Planning & Environment

Martins Creek Quarry Extension Project (SSD 6612)

Attachment A

Drawing Title
**MARTINS CREEK QUARRY
ROAD TRANSPORT ROUTES**

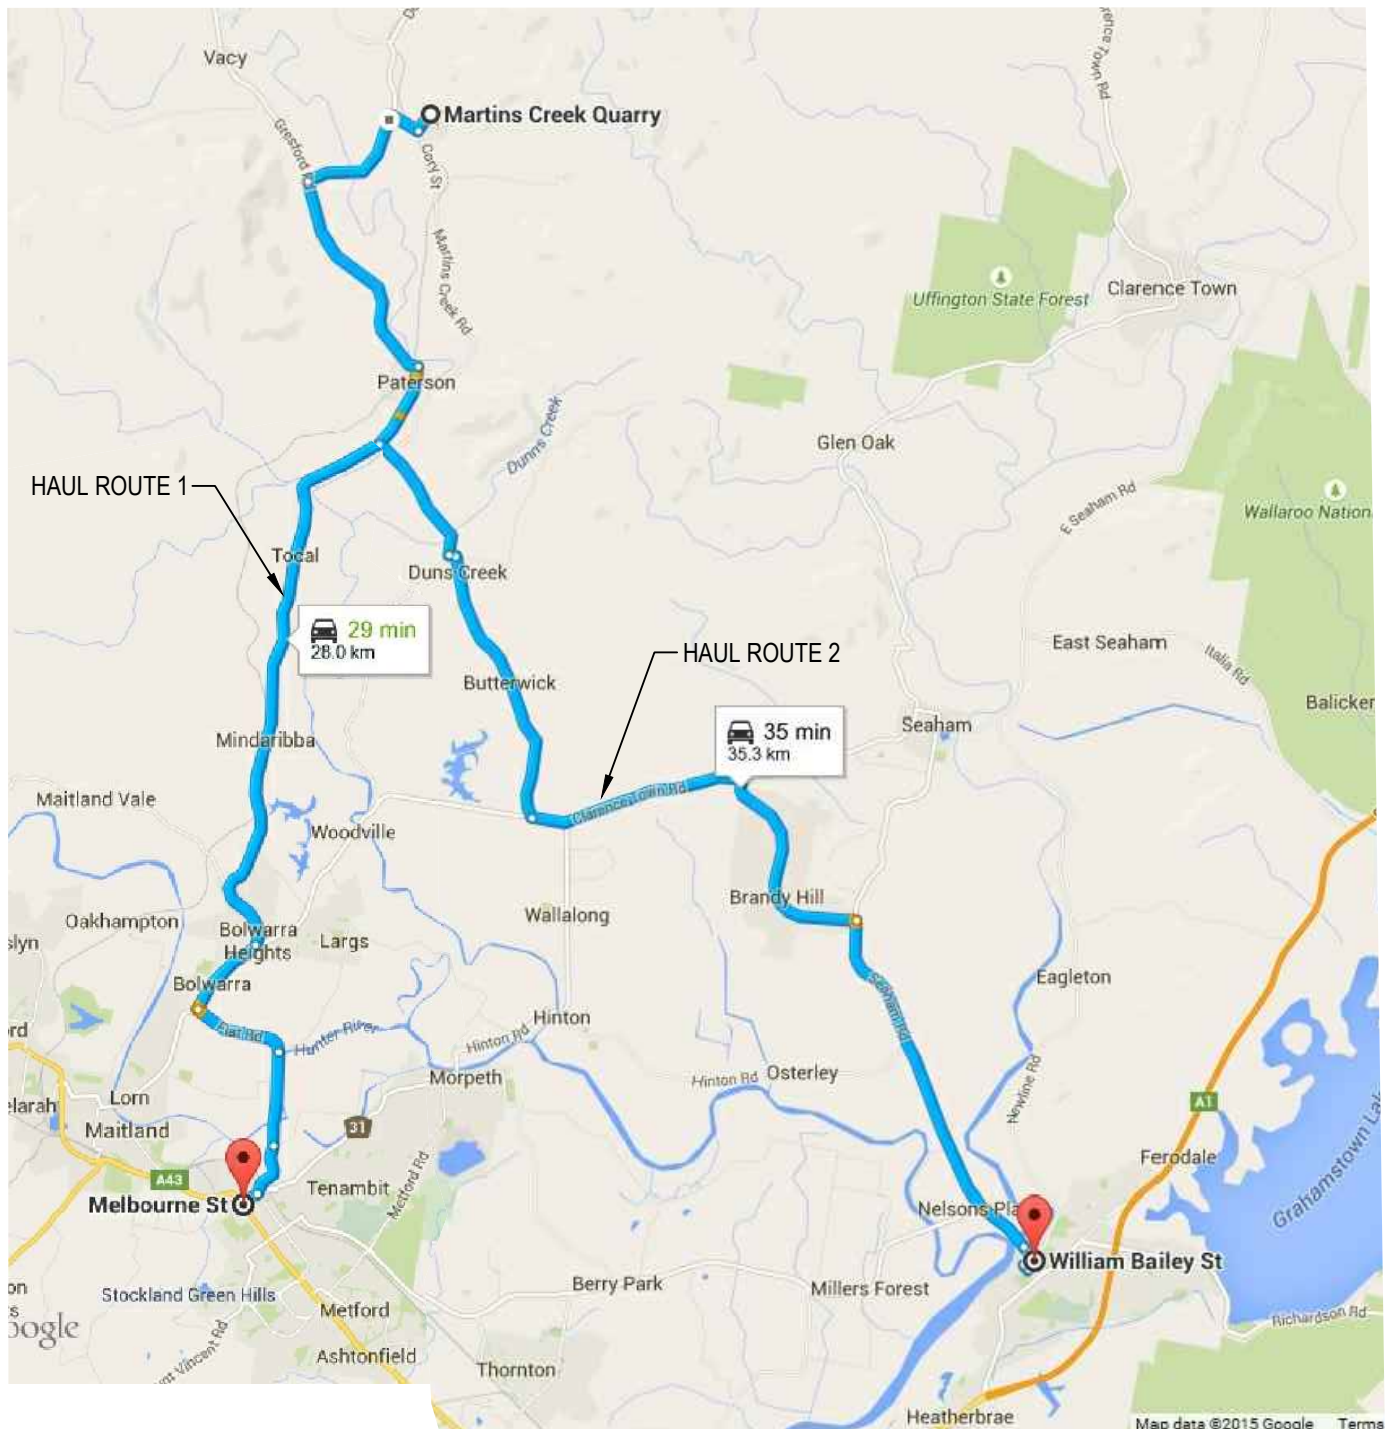
EIS and Appendix I	13. The NIA states "...secondary haulage routes such as Butterwick Road were not identified as being potentially significantly affected by changes in the proposed quarry operations". Provide justification in support of this statement that considers the revised incremental assessment following response to 1 above.
	EIS and Appendix I	14. Appendix I of the EIS includes drawings for the proposed noise wall on the western side of the rail siding at the quarry. The Department requests drawings of all proposed noise walls and/or bunds prepared to scale, with dimensions to Australian Height Datum AHD and identifying any relevant nearby features eg. privately-owned properties and residences.
Blasting	Blast Impact Assessment	15. Provide predicted blast levels for potentially affected receivers based on the different stages of the quarry extraction plan.
Historic Heritage	EIS	16. The Department requests a historic heritage assessment of the listed items and conservation areas located on the proposed haul routes (ie Paterson, Morpeth and any other relevant location) by a suitably qualified and experienced professional/s. The historic heritage assessment should consider the: <ul style="list-style-type: none"> a) potential vibration impacts (if any) of the proposed number and frequency of trucks on the structural integrity of listed heritage items; b) potential impacts to significance of the conservation area as a result of the number and frequency of trucks travelling through a conservation area; and c) the impacts of proposed intersection upgrade works on the curtilage and significance of listed items and any conservation areas.

GRESFORD AND DUNGOG ROAD INTERSECTION WORKS

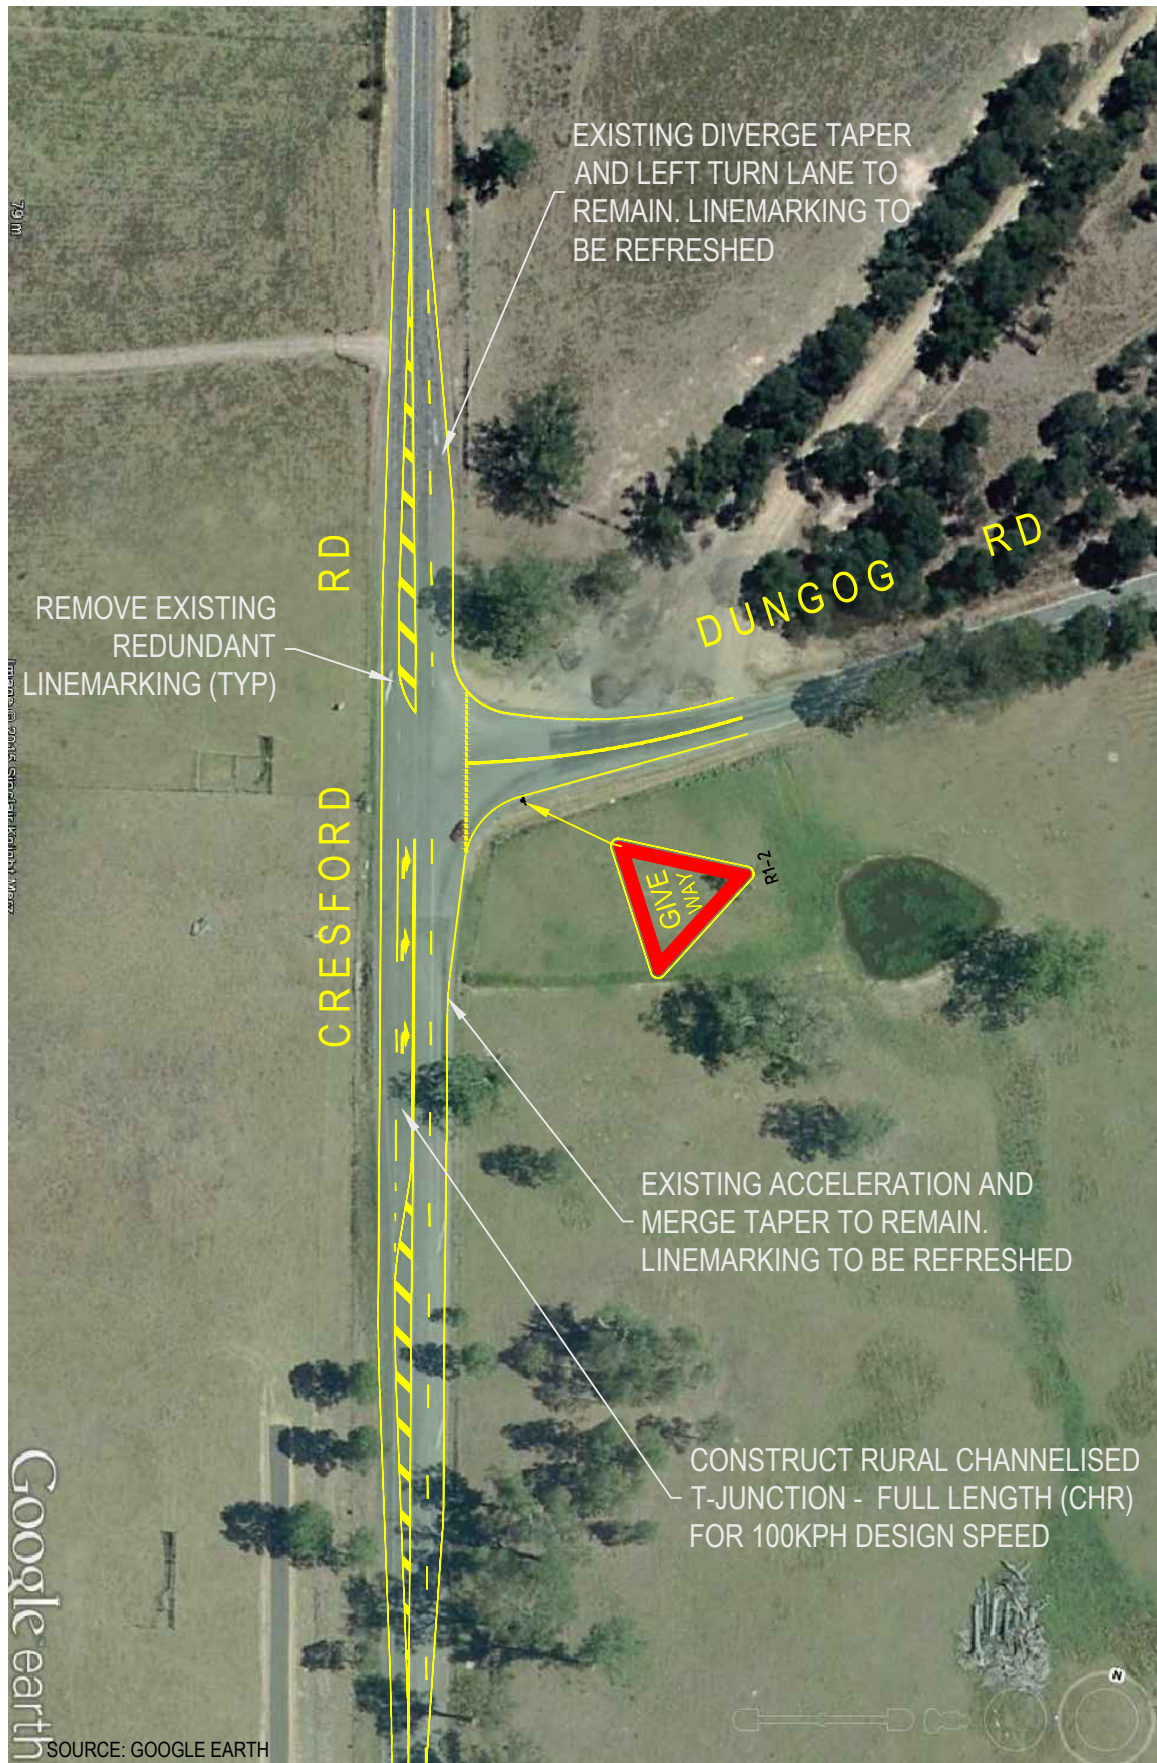
Issue	Section in EIS	Department's comments and request
Traffic and Transport	EIS and Engineering and Transport Assessment	5. The figures in the Engineering and Transport Assessment (Appendix H) appear to indicate proposed road intersection works would occur on privately-owned land. The Department requests revised figures of all proposed road intersection works that include the clear identification of property boundaries and privately-owned land. The consent of the relevant land owner must be provided for all parcels of land on which works are proposed to occur, including any privately-owned land and relevant Road Authorities (ie the relevant Council, or RMS).
	EIS and Traffic Impact Assessment	6. The Department is not satisfied that the EIS and TIA have proposed an acceptable road intersection upgrade in the village of Paterson. Specifically, the Department is not satisfied that a traffic engineering solution, such as physical separation, achieves an acceptable balanced outcome that considers the community's current use of the town centre, desire to preserve village amenity and heritage values and availability of on-street parking. The Department requests that careful and detailed consideration is given to avoiding traffic impacts to Paterson or alternatively the development of solutions that achieve a more reasonable outcome and considers the community's views on access and use of the village of Paterson.
